Date: 8 May 2018

**Application by Sembcorp Utilities (UK) Limited for an Order
Granting Development Consent for the Proposed Tees CCPP
Project**

Request for further information from all Interested Parties

Proposed Changes to the Original Application

**Figure 6.3 - Proposed Power Plant Elevations**

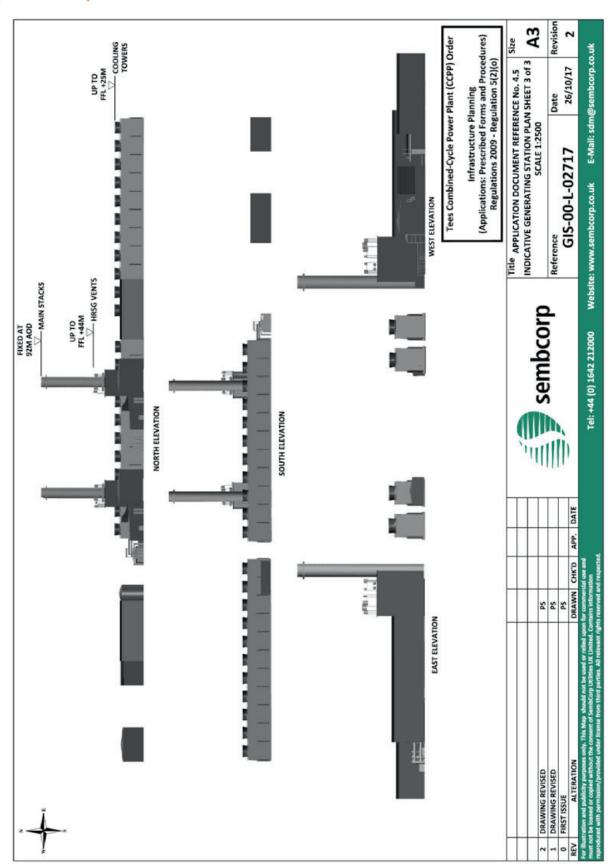
On the 2 May 2018 the Applicant submitted a request to change its original Application. The details of these proposed changes are the following aspects of the Application:

- an increase in the maximum height of the turbine hall buildings from 25 metres ('m') to 32 m; and
- an increase in the maximum height of the HRSG buildings from 44 m to 45 m.

The above comprise of Work No.1A (a) and Work No. 1A (b) of the draft DCO [Examination Library Ref: APP-005]. The current maximum heights (25 m and 44 m respectively) are set out in Schedule 2, Requirement 4 of the draft DCO.
